Addendum No. 1

RE: Contract ID: C201789

Cumberland County (I-4915)

I-95 from pavement joint at North side
of the I-295 to Harnett County Line

PROJECT NO.	SHEET NO.	TOTAL NO.
I-4915	4	
39996.3.GV1

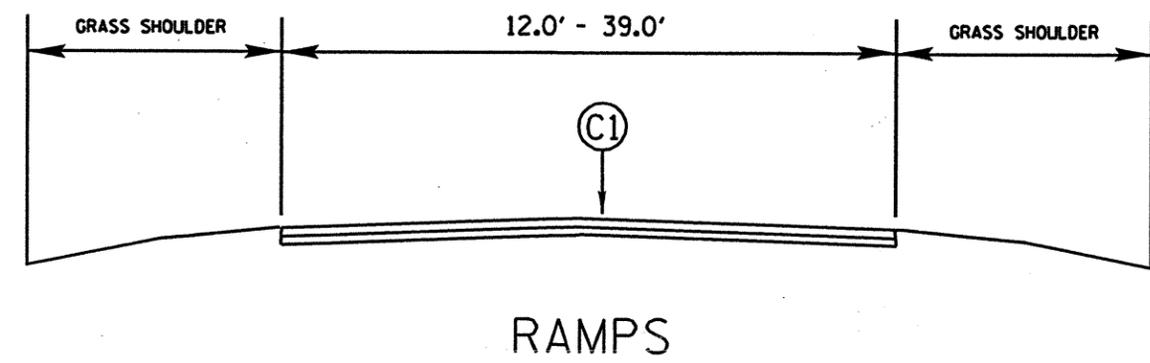
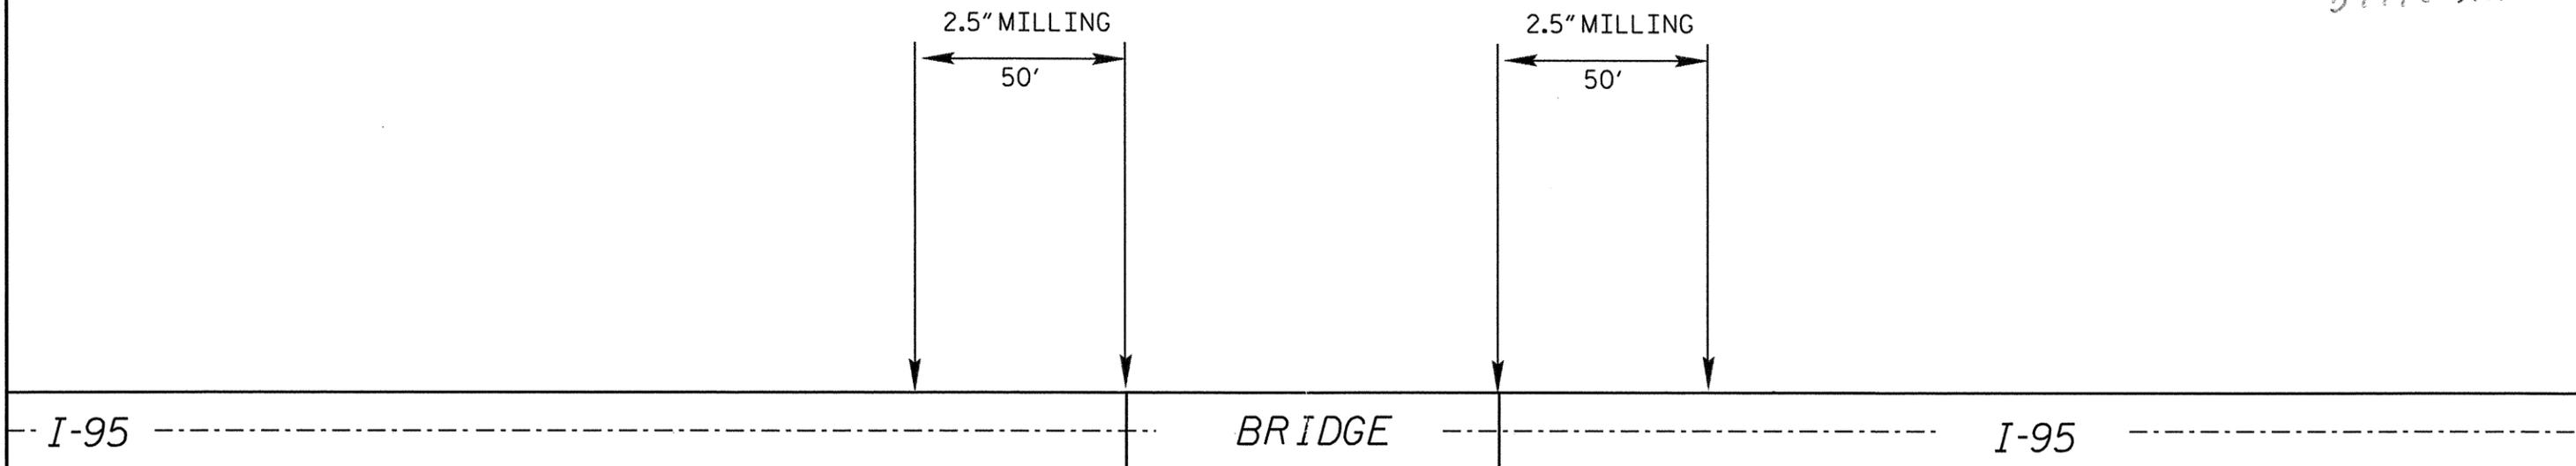
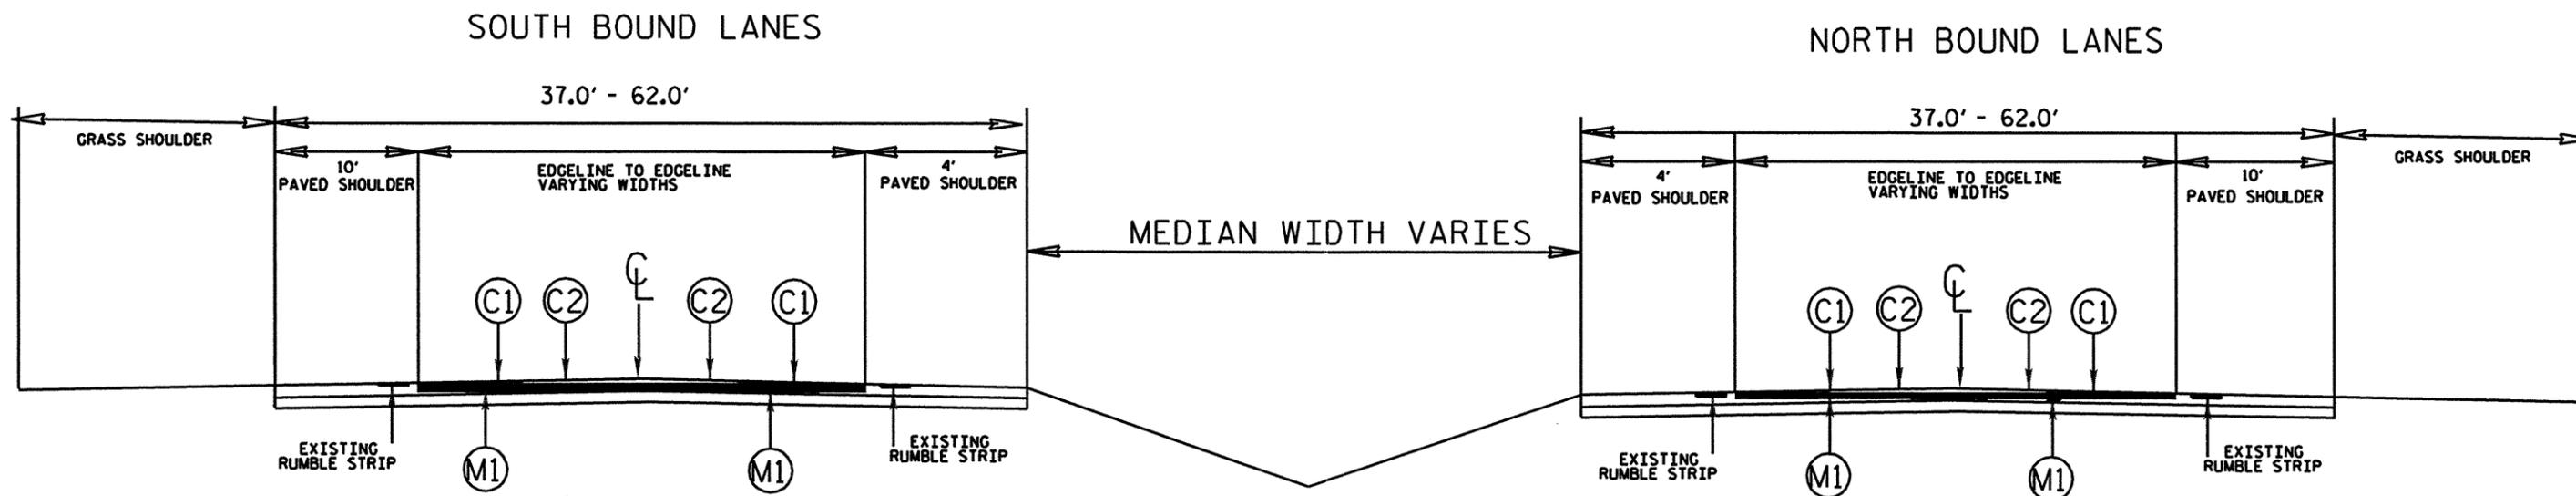
Sheet No. 4 has been revised to include the Pay Item of "Asphalt Binder for Plant Mix Grade PG 70-28". Please void Sheet No. 4 in your Sketch Maps and staple the revised Sheet No. 4 thereto.

<u>New Pay Item</u>	<u>Quantity</u>
25-1567000000-E-SP Asphalt Binder for Plant Mix Grade PG 70-28	602 Tons
